1. Conference Rooms 101,103, 104, 207, and 217 are scheduled to have telecom recessed wall stations, underslab conduit, and recessed floor outlets to support operation of digital displays as described in item #1.18 of Electrical Addendum #1 issued as part of General Addendum #2 dated April 16,2009. ASK 18, pages 2, 3, 4 provide specific locations for floor boxes and underslab conduit.

RECESSED FLOOR BOX AND CONDUIT LOCATIONS - FIRST FLOOR

RECESSED FLOOR BOX AND CONDUIT LOCATIONS; AND NEW CABLE TV OUTLET LOCATIONS - SECOND FLOOR

FIRST FLOOR POWER PLAN-PART A

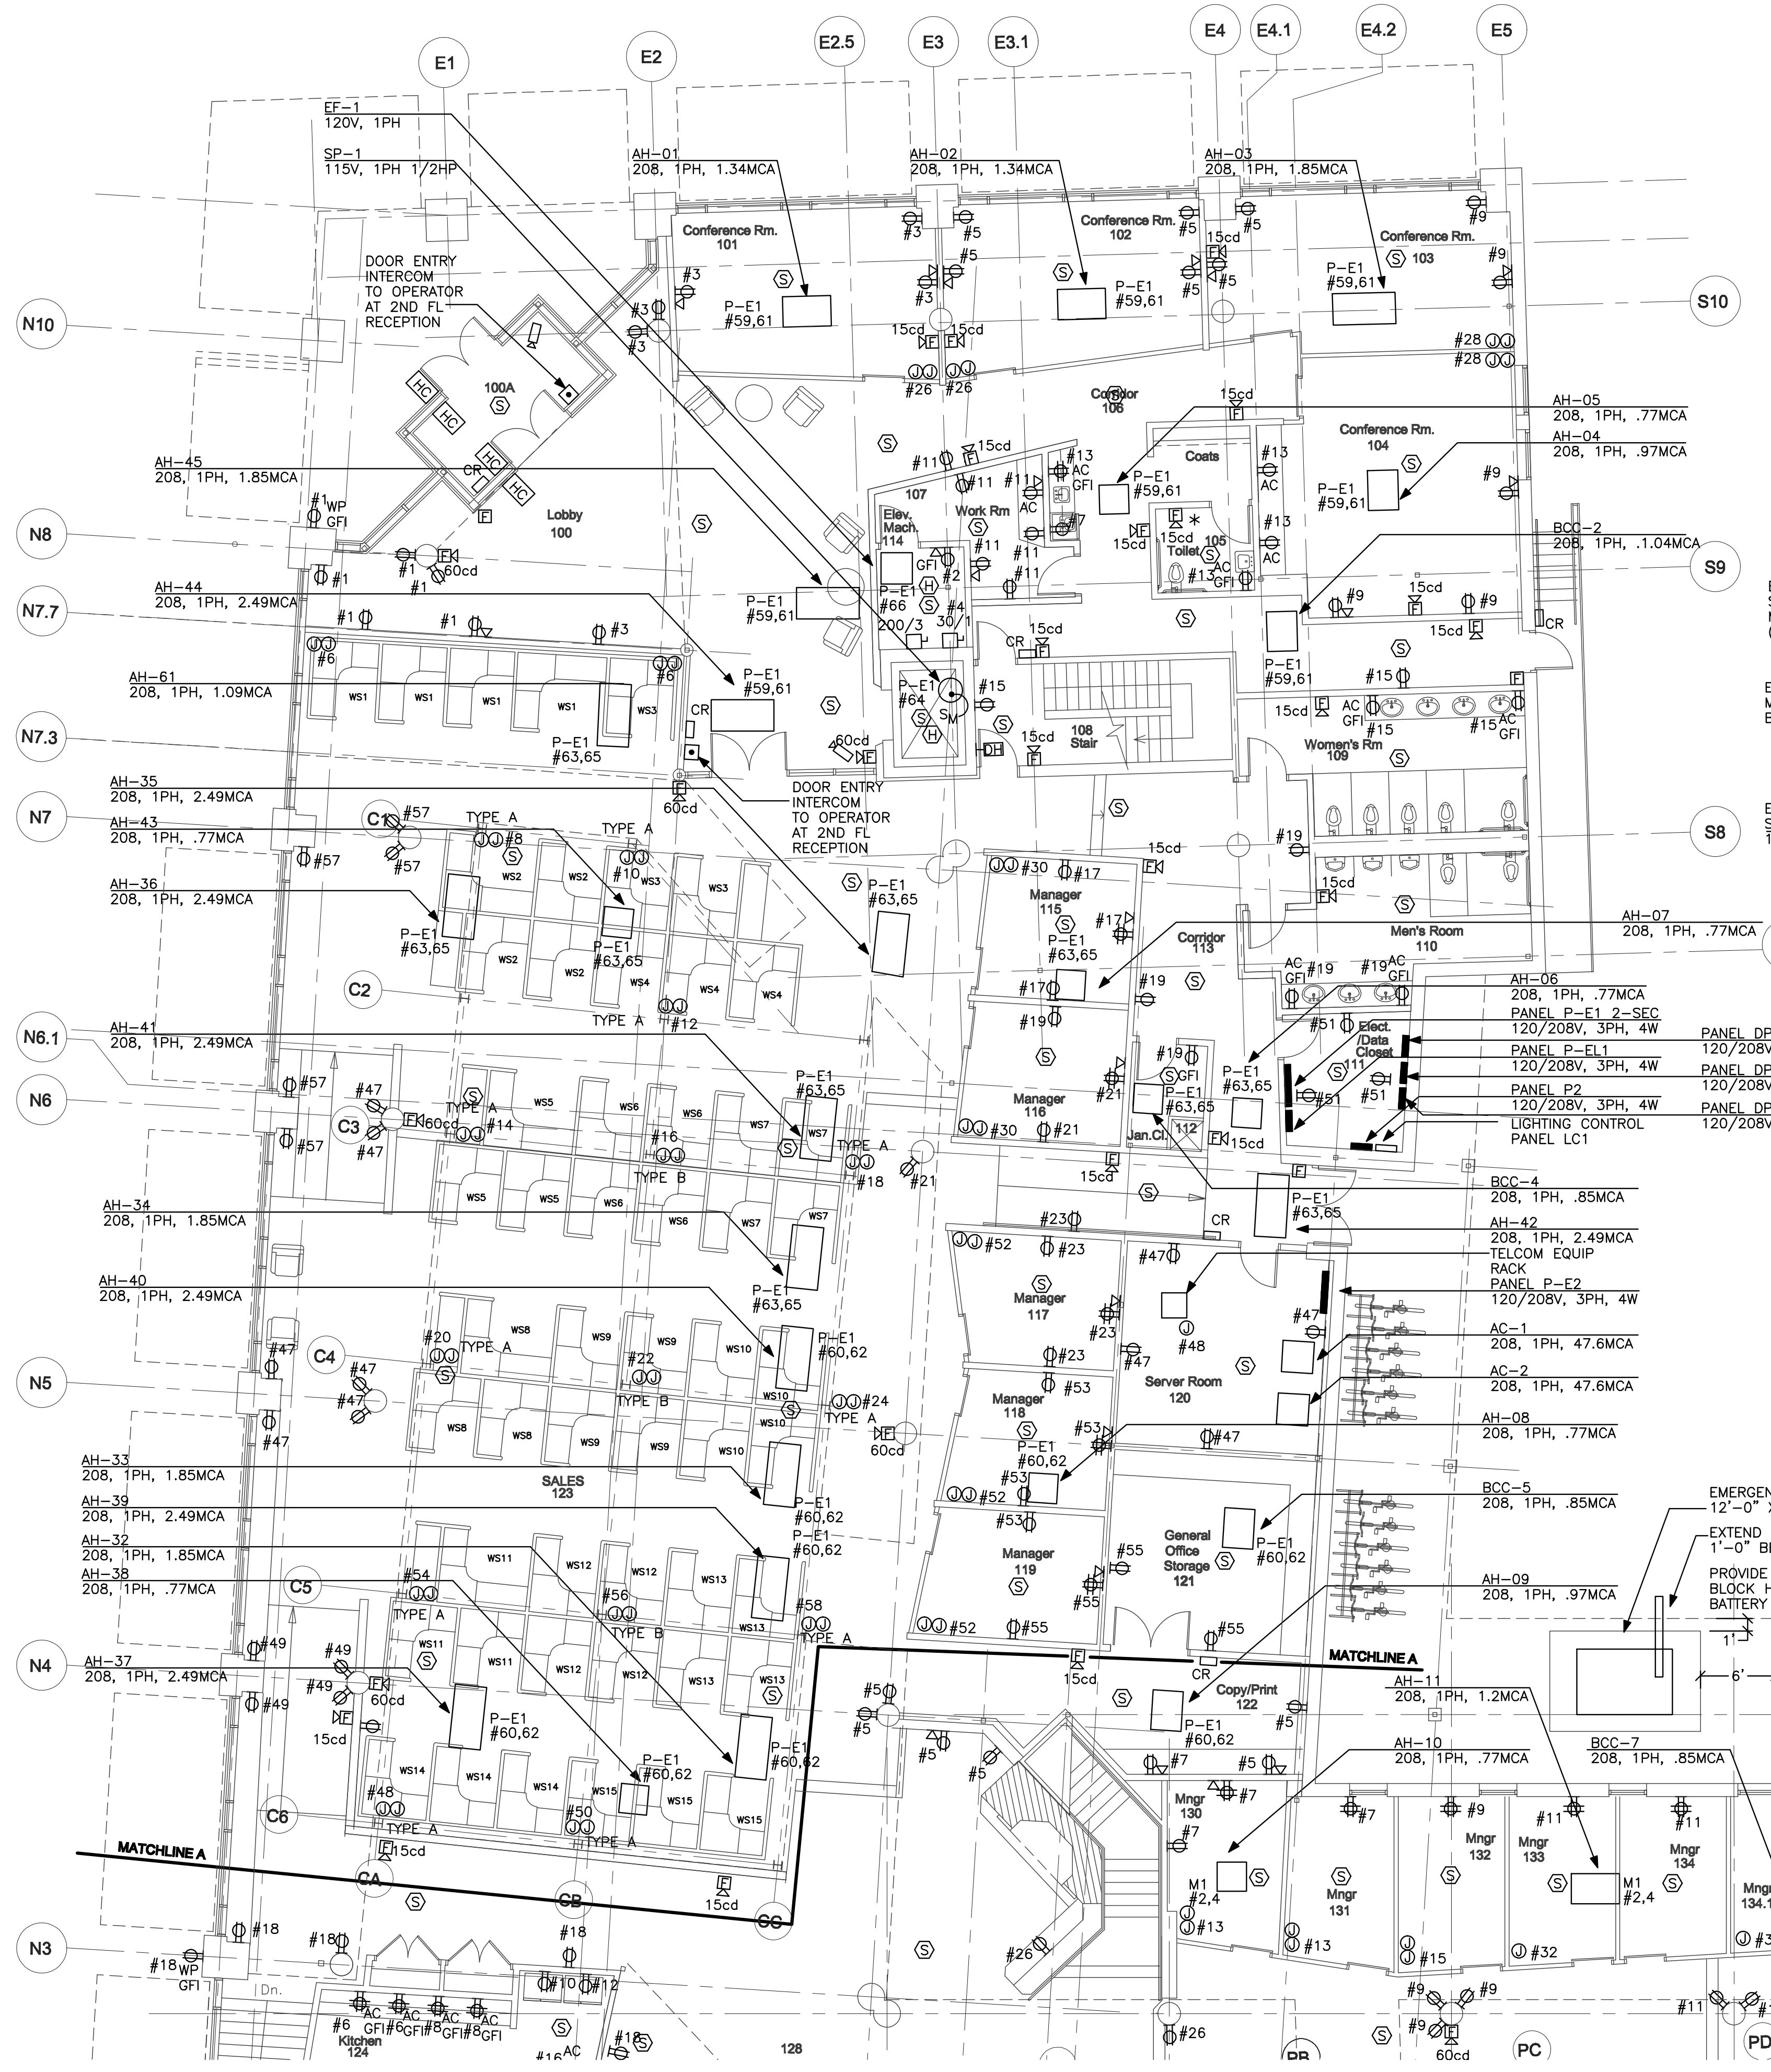
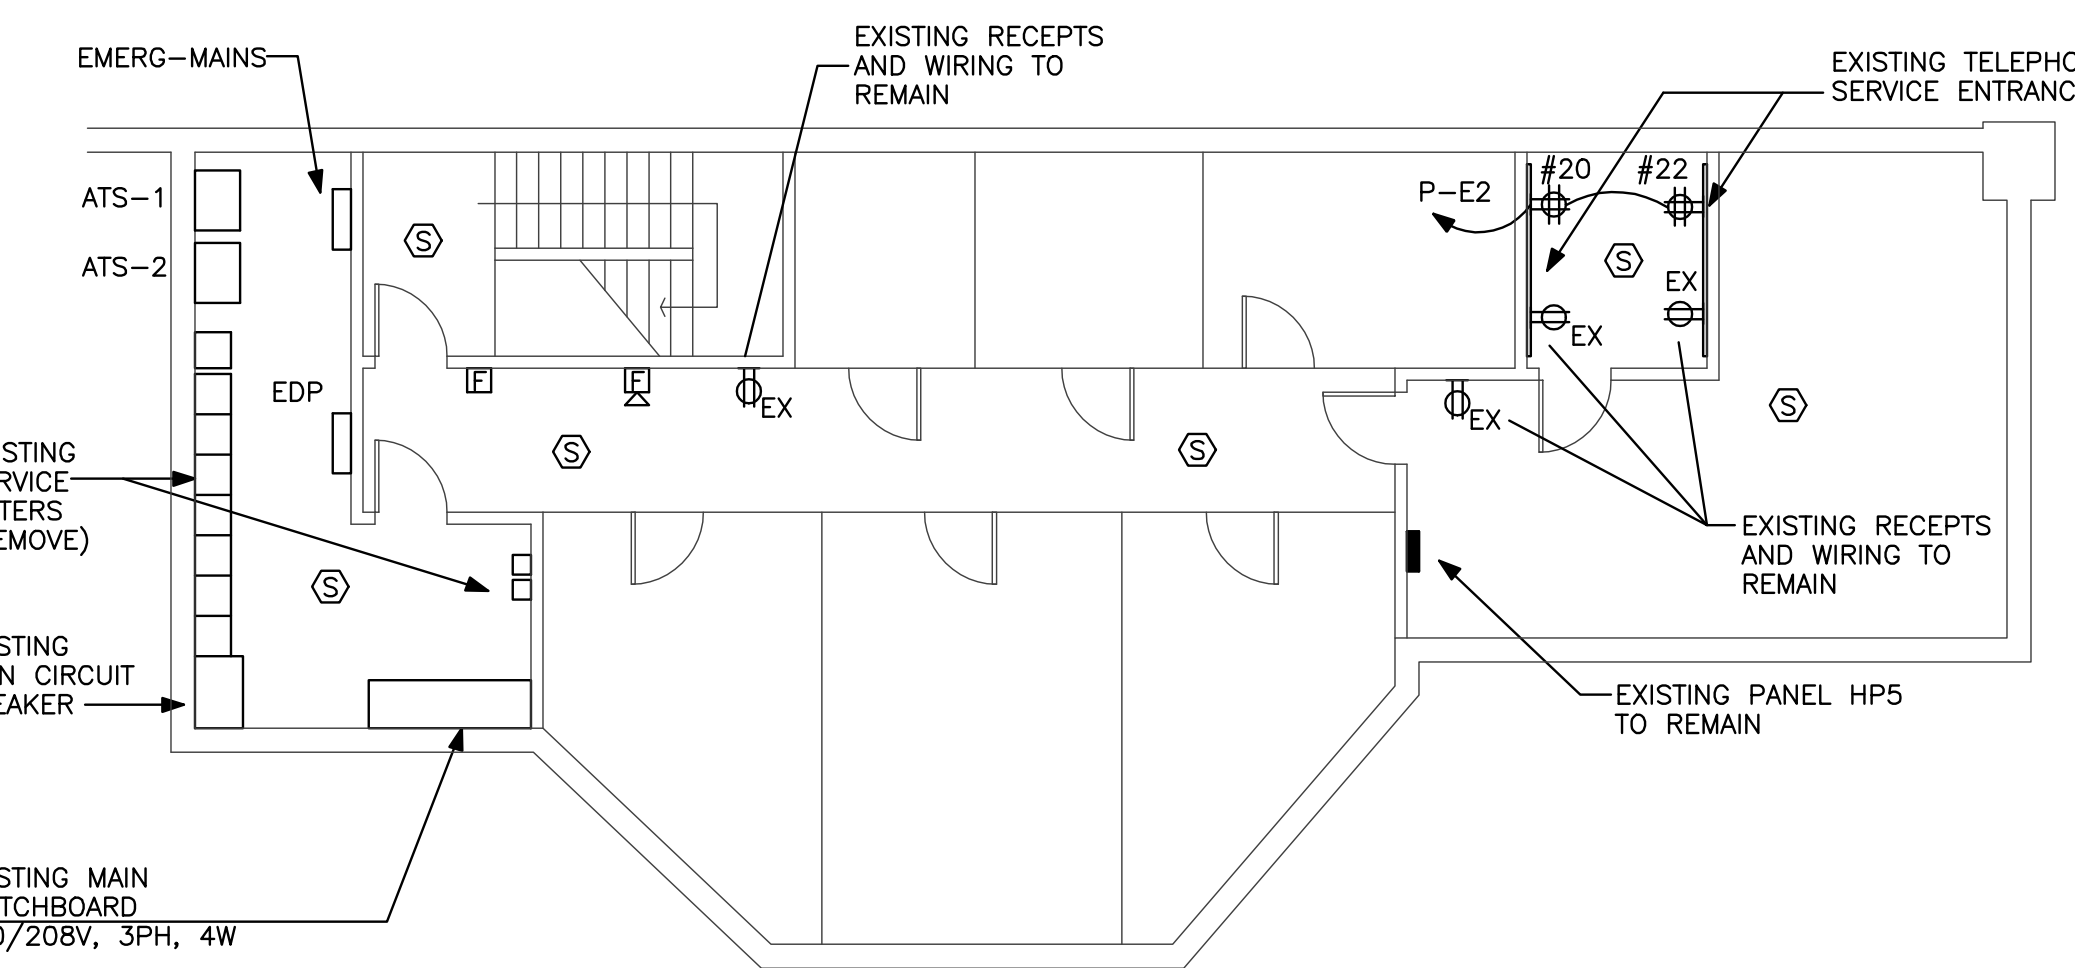
4. Add two cable T.V. outlets at office 201 as shown on ASK 18 page 2.
5. At the west wall of Lobby 100, a power outlet and data outlet are shown on E1.1. A cable T.V. outlet was added per item #1.13 of Electrical Addendum #1 issue with General Addendum #2 dated April 16, 2009. Revise this installation to provide upper and lower telecom wall stations and cabling similar to installation for Bar 126 described in item #1.21 of Electrical Addendum #1.
